Recommendation Report for Planning Permission

REF NO: M/58/25/PL

LOCATION: 86 Ancton Way
Elmer
PO22 6JP

PROPOSAL: Demolition and erection of 1 No dwelling (resubmission following M/22/25/PL).
This application is in CIL Zone 4 and is CIL Liable as a new dwelling.

PROPOSED SURFACE WATER DRAINAGE
Scale 1:100

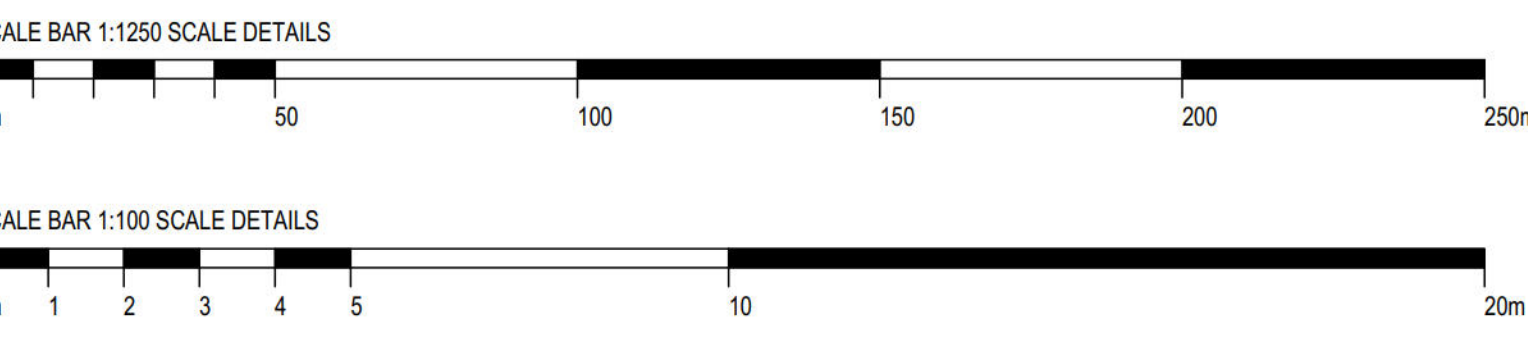
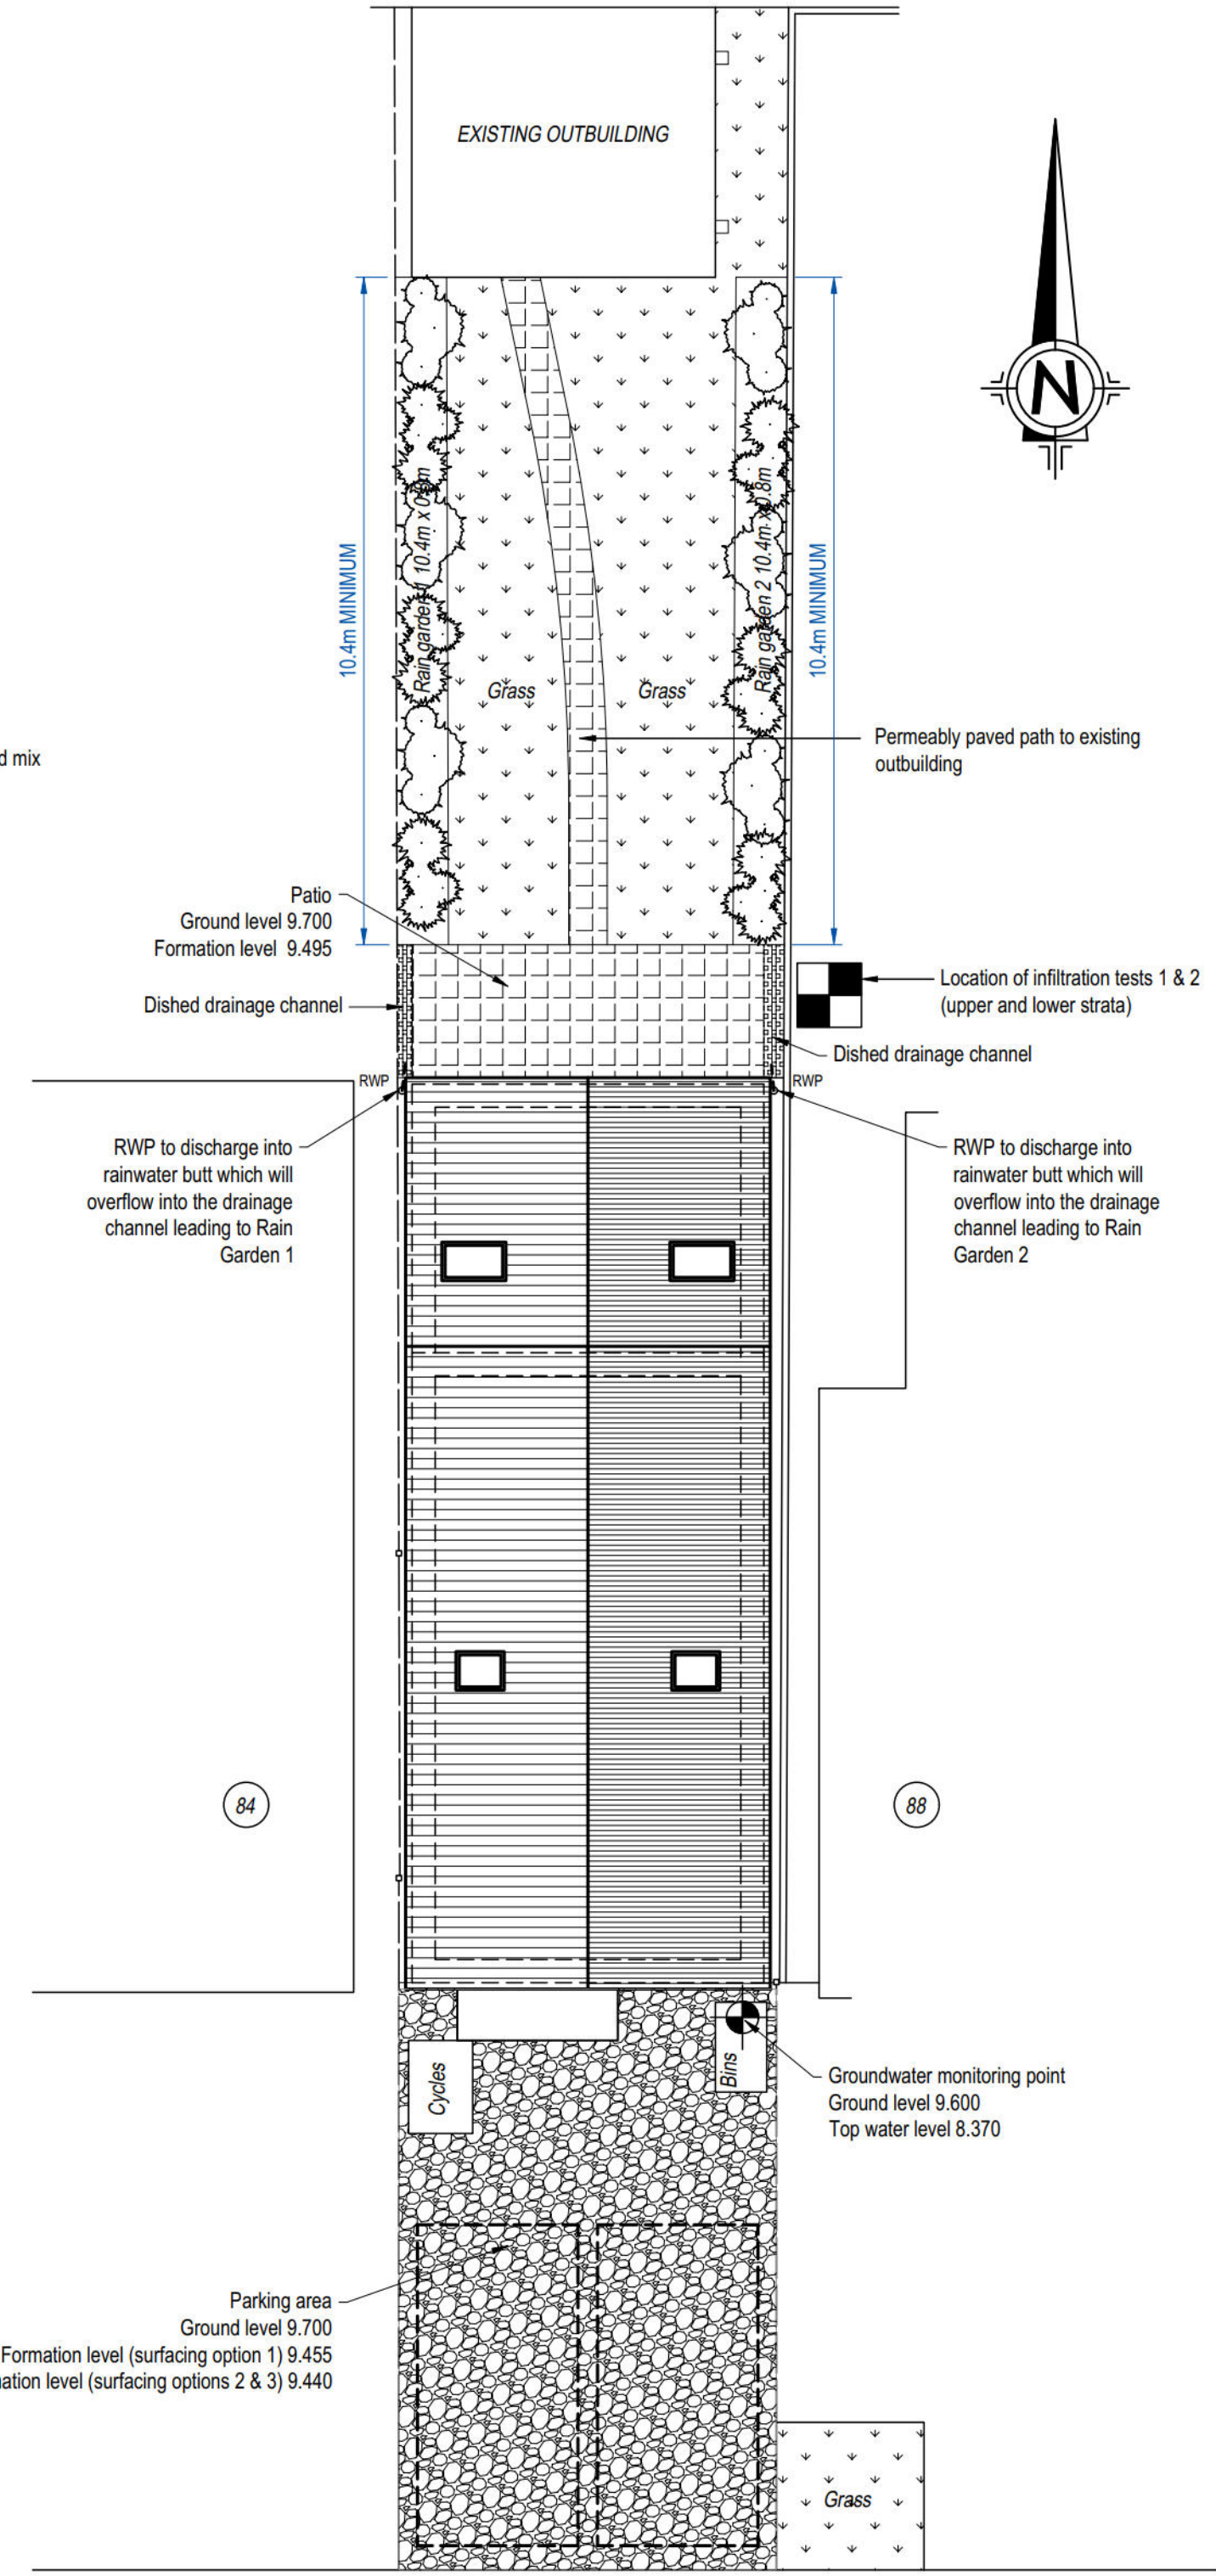
- Objection to National Standards for SuDS (NSfS) standard 1 (Runoff Destination).
- Insufficient evidence submitted to confirm infiltration is viable on site and no alternative sustainable

- disposal location has been identified.
- Lack of clear evidence of the strata composition and to confirm that infiltration into made ground has not occurred.
 - The infiltration testing has not been undertaken at the correct depth, nor in a methodology recognised the SuDS Manual or the National Standards for SuDS.
 - No objection subject to conditions in relation to NSfS standards 2-7.

Clear evidence identifying the strata composition on site and that confirmation infiltration into made ground has not occurred has not been provided. Additionally, while infiltration testing has been provided, the infiltration testing has not been undertaken at the correct depth, nor in a methodology recognised the SuDS Manual or the National Standards for SuDS. On this basis, the ADC Engineers objected as the submitted information has not adequately demonstrated that infiltration is viable.
